**Transport
for NSW**

Our Reference: SYD21/00666/03
DPIE Reference: SSD-27208140

**ST ALOYSIUS COLLEGE, ROZELLE CAMPUS
48 VICTORIA ROAD AND 2A-2B GORDON STREET, ROZELLE**

Thank you for requesting Transport for NSW (TfNSW) to review the Environmental Impact Statement and Appendices for SSD-27208140 St Aloysius College, Rozelle.

Swept Path Analysis

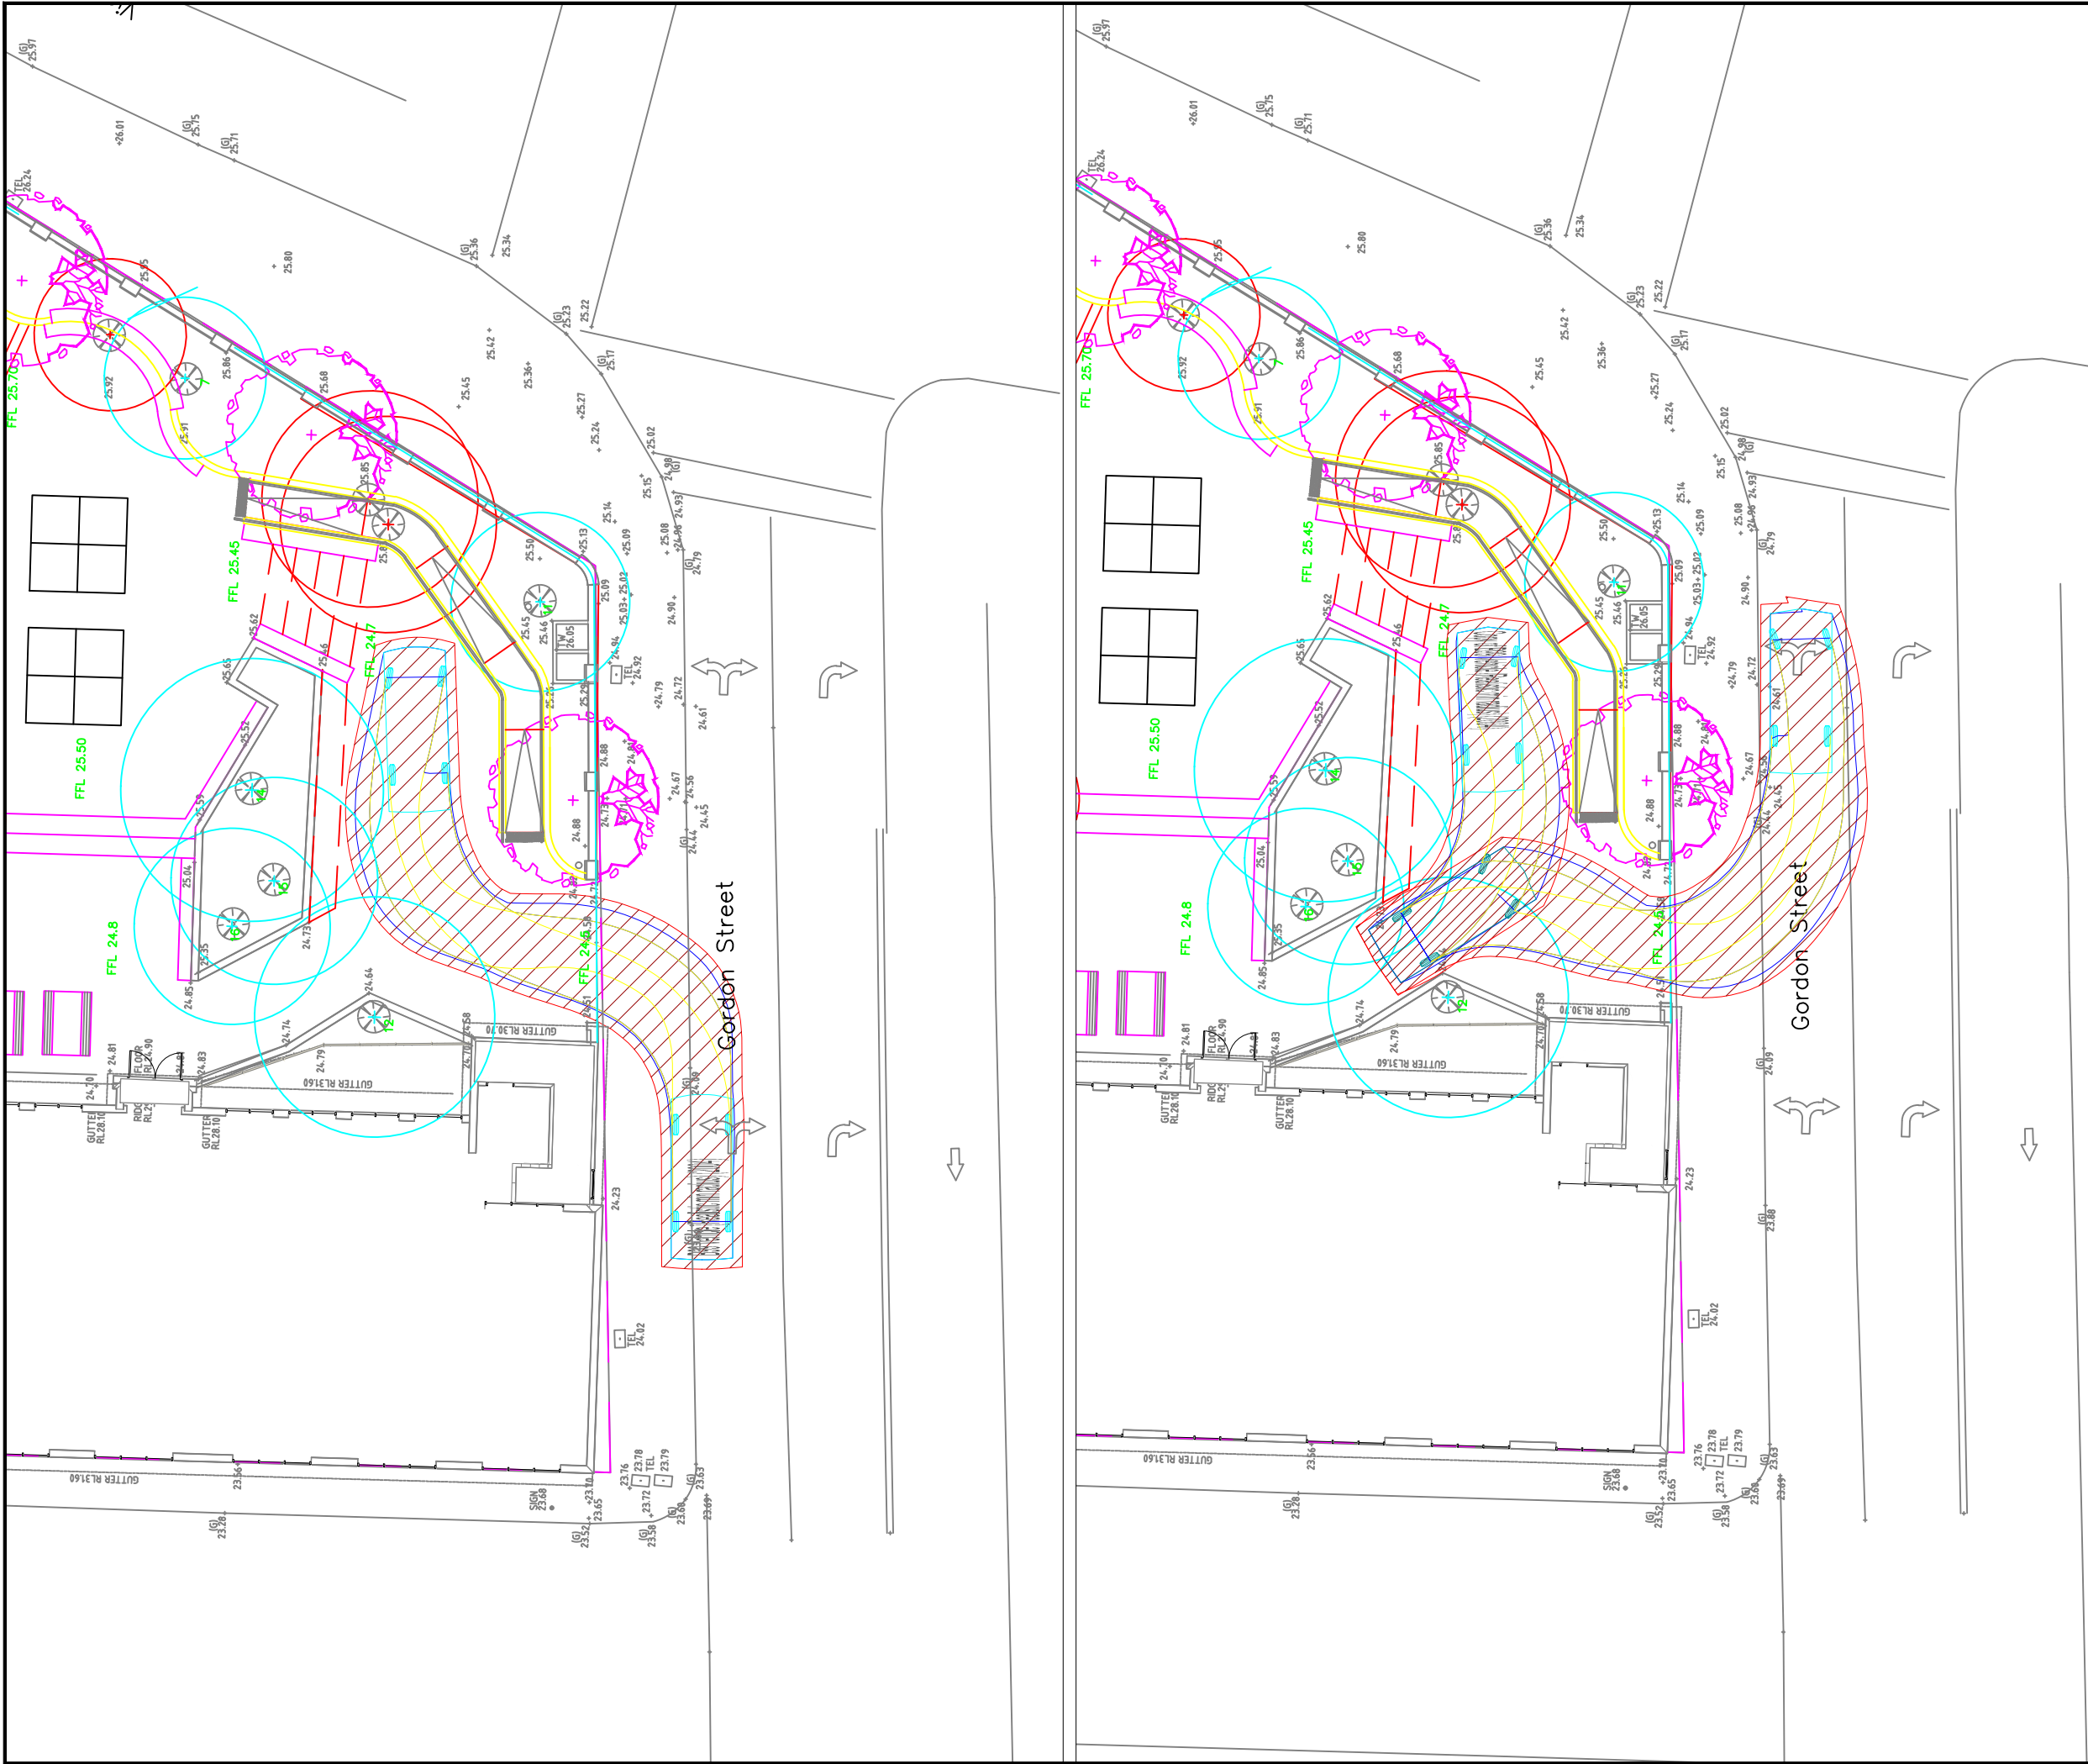
TfNSW notes that the submitted swept paths for vehicles entering the two locations on Gordon Street are not acceptable in their current form (appendix E and F in the Transport Impact Assessment).

TfNSW requests that the Applicant addresses this as part of the RtS in which the swept paths showing vehicle entering and exiting the roadway using the current driveways and line-marking through Gordon Street.
